2024/0935

55 Longley Street, Barugh Green, Barnsley, S75 1NR

Erection of single storey rear extension and front porch to dwelling

PROPOSED SIDE ELEVATION REAR EXTENSION

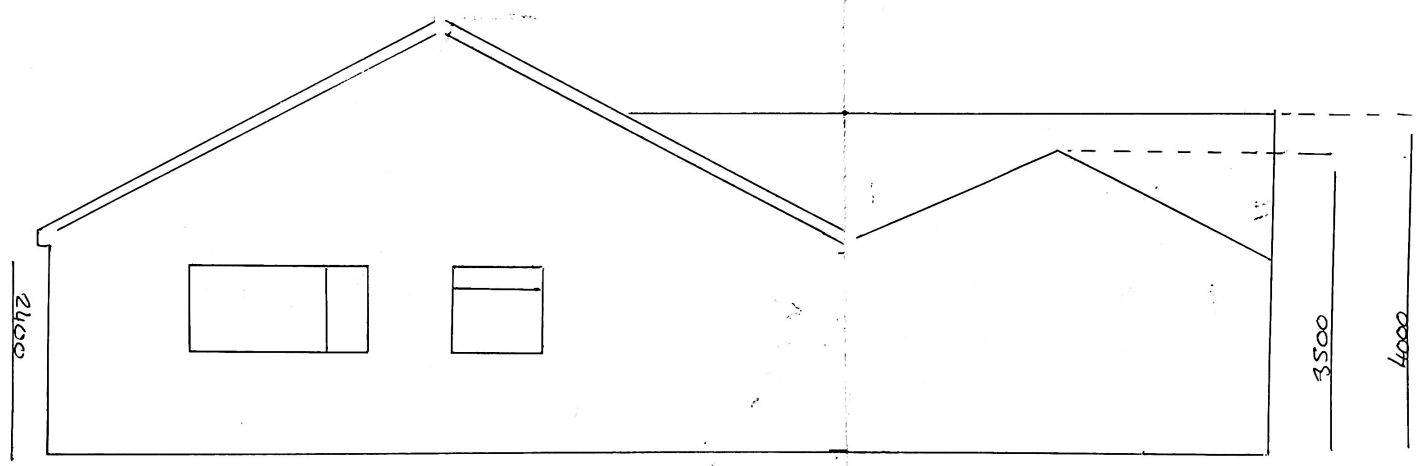
The side extension does not provide any side elevation windows to the west, preventing any overlooking issues. Given the site dwelling is set forward of 57 Longley Street, the proposed impact of the side extension is reduced to 2 metres projection rearwards of 57 Longley Street. This lessens the impact of the gable elevation on the rear of the neighbouring dwelling. Furthermore, neighbouring 57 Longley Street is set approximately 1 metre above the site. This further lessens the impact of the 3.5 metres gable elevation and reduces the dominance therefore weighing significantly in the proposals favour.

The rearward projection of 5 metres is acknowledged to be greater than the 4 metres outlined within the House Extensions and Other Domestic Alterations SPD. However, because a proposal of up to

6 metres rearward projection with the same eaves' height, although without the side extension, could be erected under permitted development (not requiring planning permission) it would not be prudent to enforce the 4 metres rear projection in this case. The extra metre is not considered to have a detrimental effect to the visual amenity of the property over and above what a 4 metre extension would provide. Substantial boundary treatment is evident to the adjoining property and the west side neighbour is set 1 metre above the site lessening the impact. A pitched roof is provided along with a shallows pitch which lessens the dominance of the proposal. The pitched roof is also preferred to a flat roof. This weighs significantly in favour of the proposal.

The side extension benefits from a pitched roof replicating the roof form of the existing property and a 2.2 metres sideways projection allowing the proposal to be in line with the House Extensions and Other Domestic Alterations SPD. The ridge height of 3.5 metres is modest and allows the extension to remain subservient to the property along with the substantial set back to the rear of the property. This weighs substantially in favour of the proposal.

The use of light grey render proposed to the rear and side extension is not considered to match the street scene however the use of 'Off White or Cream' would be considered acceptable as this would allow the proposal to closely match the stone features on the street scene and the proposed porch. A condition will be included on the decision notice in reference to this.
